Application by Port of Tilbury London Limited for an Order granting Development Consent for the Proposed Port Terminal at the Former Tilbury Power Station

Written Submission of Network Rail Infrastructure Limited in relation to the Issue Specific Hearing on the draft Development Consent Order

Planning Inspectorate Reference: – TR030003

Title:
Port of Tilbury (Expansion) Order 2017
Land Plans - Regulation 5(2)(i)
Sheet 3

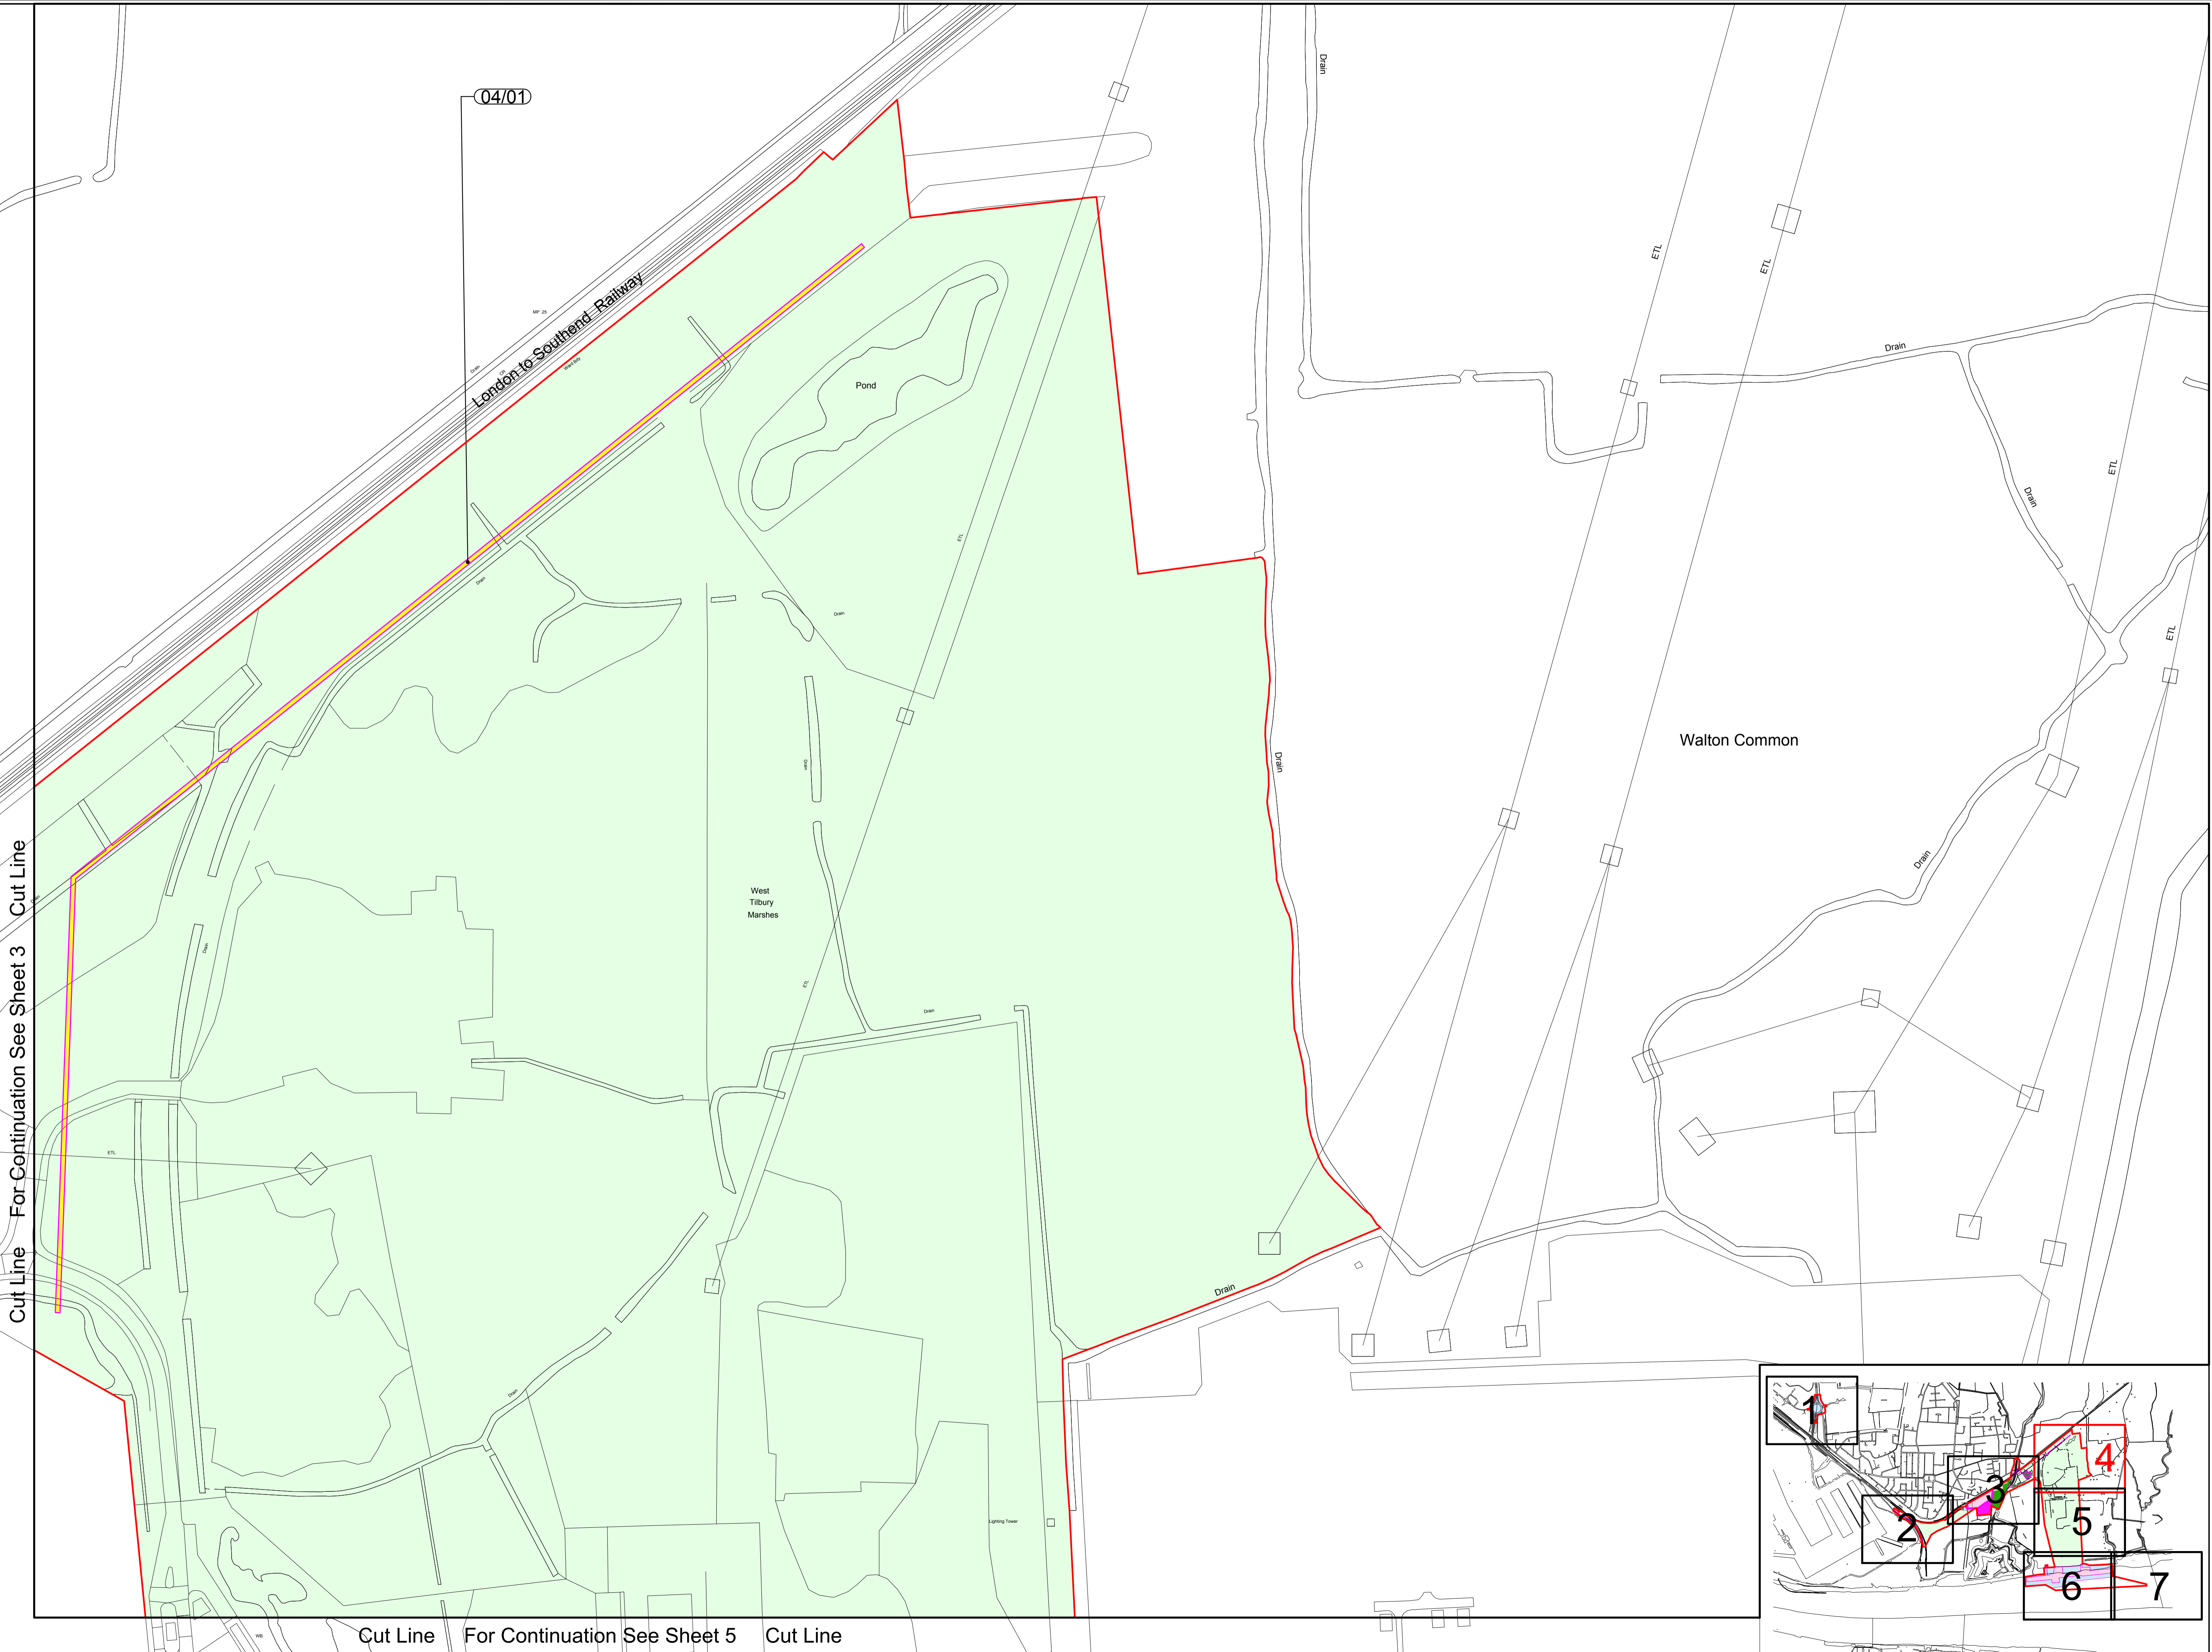
- 3.1 The Land Plans – Sheet 3 submitted by the Applicant at Deadline 2 [REP2-010] show in grey the 'areas to be excluded from the Order Limits', which include a section of operational railway. NR requests the Panel to ask the Applicant to amend the Location plan [APP-007], the Works plan and any other plans showing the extent of the Order Limits [APP-010] to exclude the operational railway from the Order Limits and resubmit these to the Panel at the next appropriate Deadline.

4.2 Network Rail requests the Panel to ask the Applicant to resubmit the relevant plans showing the amended Order Limits, excluding the operational railway from the Order Limits, as shown in the Land Plans – Sheet 3 **[REP2-010]**.
